RE: RE: 5 Bell Lane Brookmans Park Hatfield AL9 7AY - 6/2021/1132/LAWP

Isaac Liu
Principal Enforcement Officer
Welwyn Hatfield Borough Council
Email: I.Liu@welhat.gov.uk

Drg.No: AT821-22B

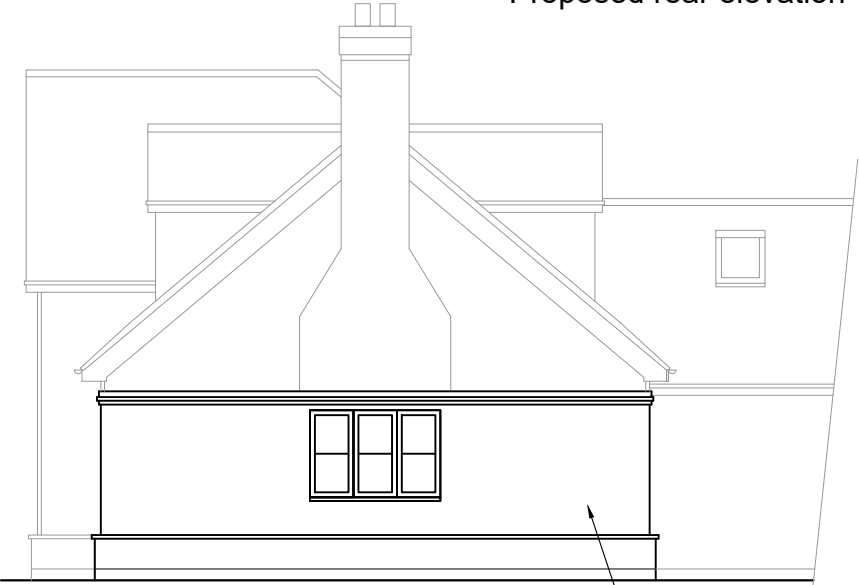
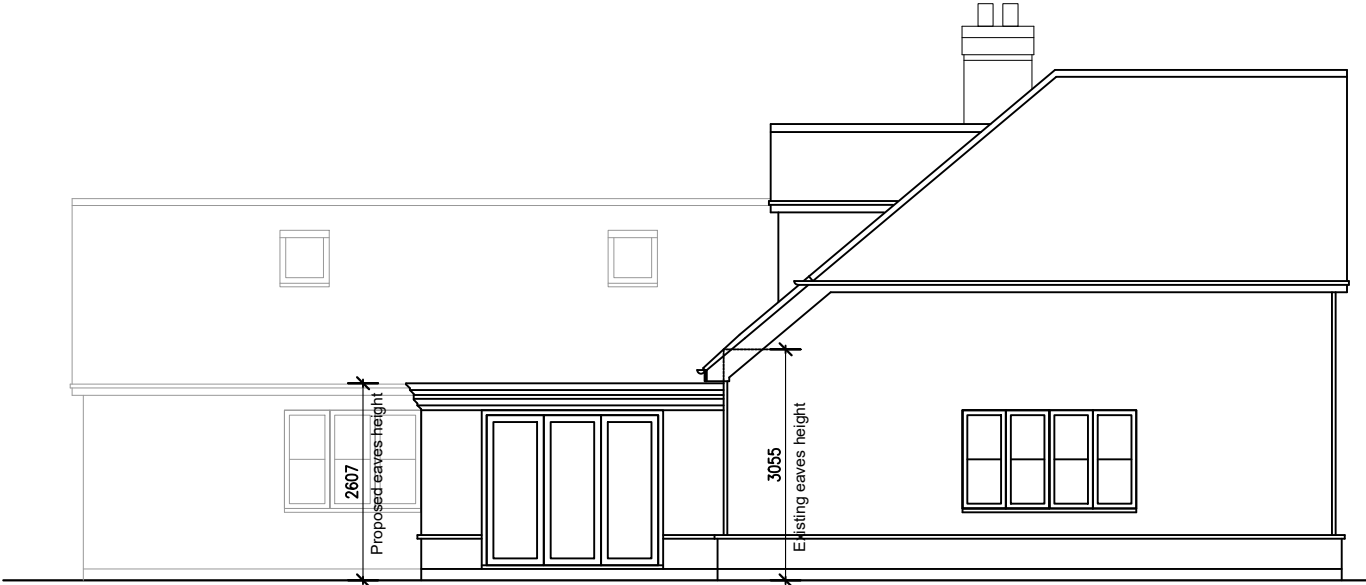
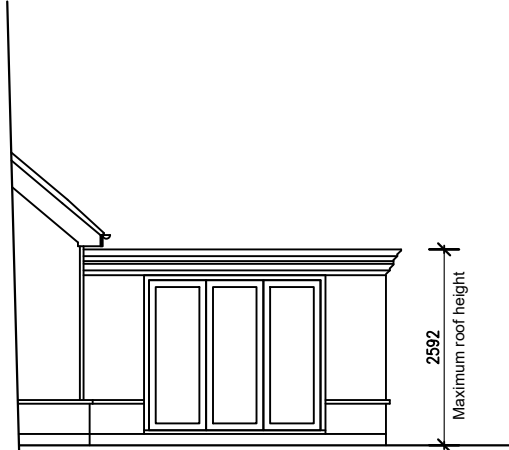
I do not agree with this as the Council only decides applications based on submitted evidence such as drawings presented by the agent. Specially in this application, the case officer has found the drawings submitted show , ' the proposed gap between the triple garage and the side elevation of the house does not constitute as a functional gap. From the plans submitted it would appear that the garage is linked to the dwelling house' and hence unsatisfying the scope of Class E of the GDPO.

Although it is acknowledged the tick box criteria has been fulfilled this is only as a guide only . From reviewing the plans a wall is attached to the main house to the triple garage.

The drawing AT821-22A dated June 2019, annotations state, ' fence or wall recessed' between the main house and detached garage. Officers decide applications based on the drawings submitted.

1. the proposed gap between the triple garage and side elevation of the house does not constitute a functional gap as from the plans submitted it would appear that the garage is linked to the dwellinghouse.
2. no elevation drawings of the proposed retaining wall have been provided
3. the drawings for the swimming pool refer to the building having two front elevations

In respect of point 1 the proposal is for a **detached garage** - the description on the application says this as does your description - there is a clear gap between the house and garage and that is why it is called a detached garage. You suggest only that it **appears to be linked** and when you queried this both myself and the architect (who also sent an amended plan to clarify this point) informed you that it was not linked to the house - there was a screen fence on the plan which you appear to have misinterpreted. However, this should not have mattered as if you did not regard it as detached then it would be regarded as a side extension to the house and benefit from class A permitted development - your section j refers.

Rev.	Description.	Date.
	Scale : 1:50 at A3	
	Date : June 2019	Drawn by: AT
Drg.No: AT821-23B

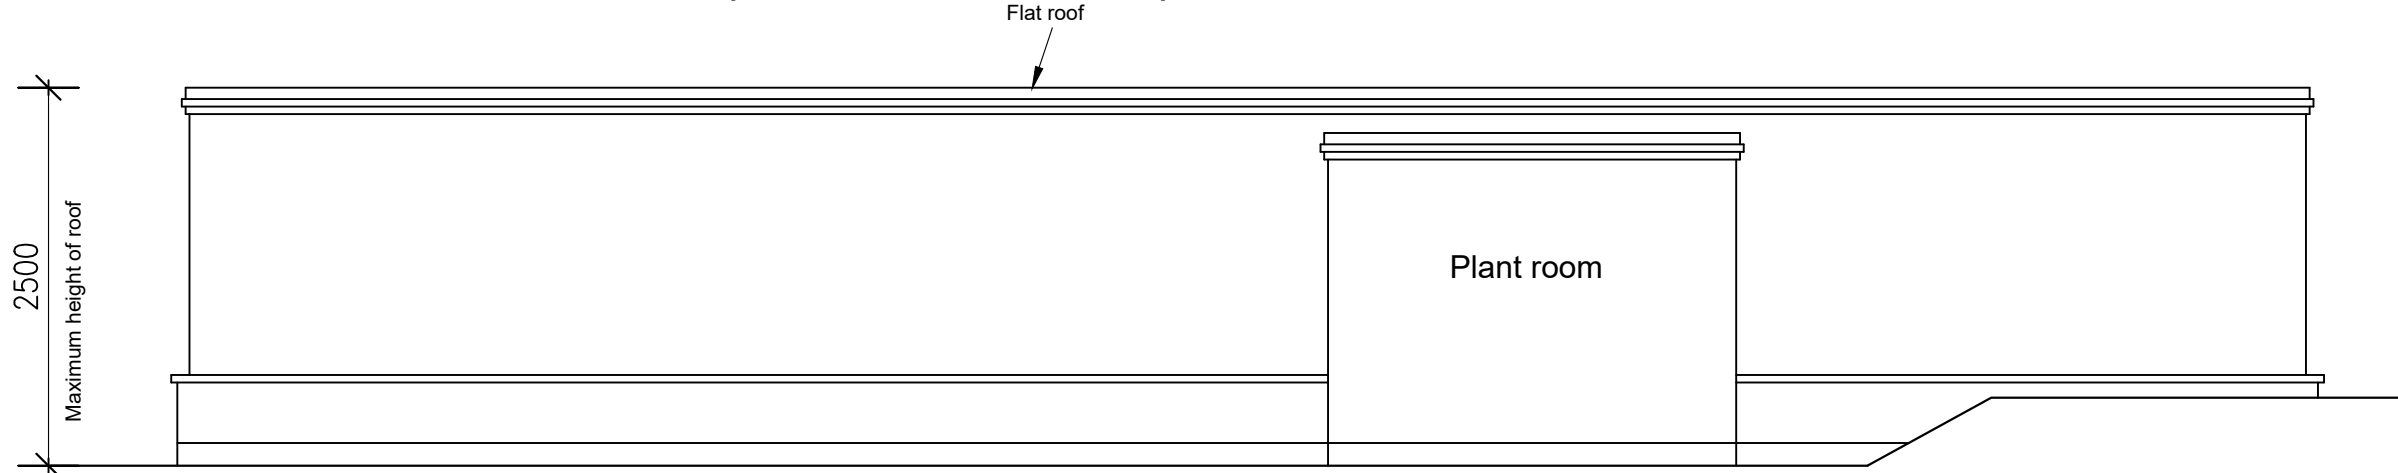
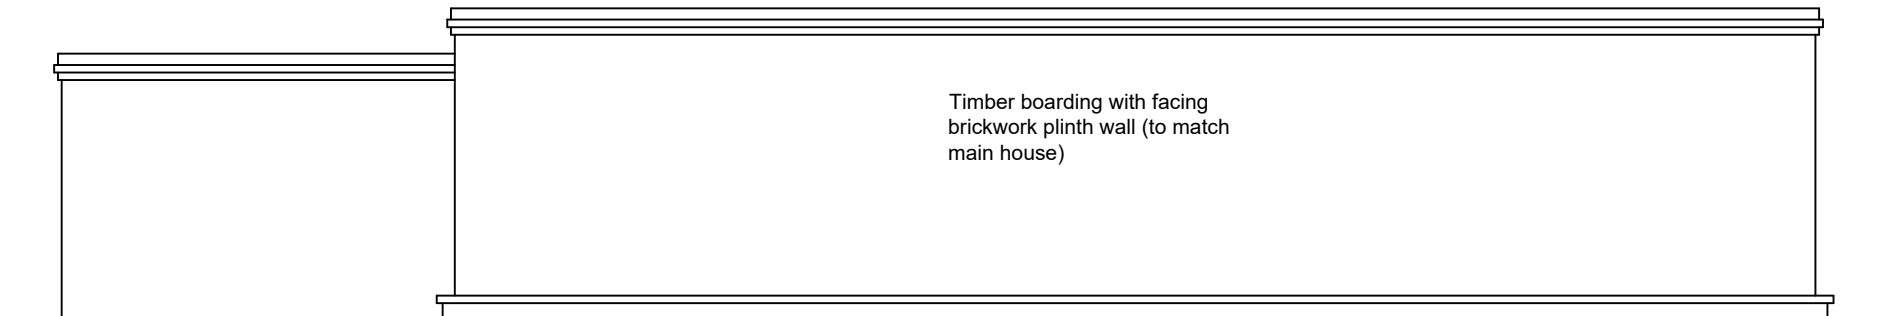
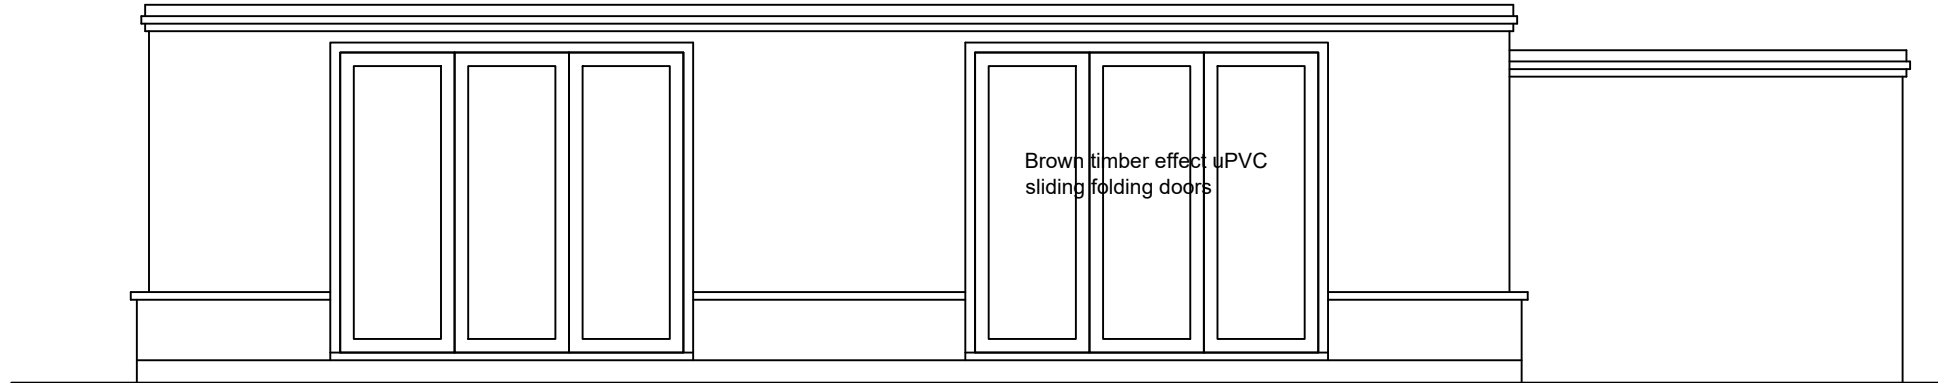
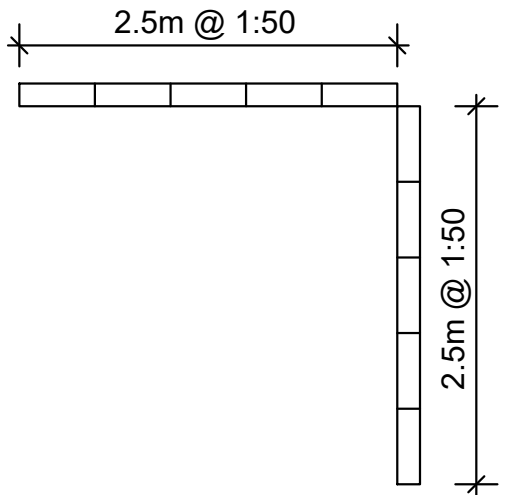
In respect of point 2 the application does not include a retaining wall - this is an existing dwarf patio wall less than a metre high and not part of the application. Again I informed you of this as did the architect.

In respect of point 3, whilst this may be a reference error on the drawing it has no bearing on permitted development rights. The architect amended the plan when you drew this to attention.
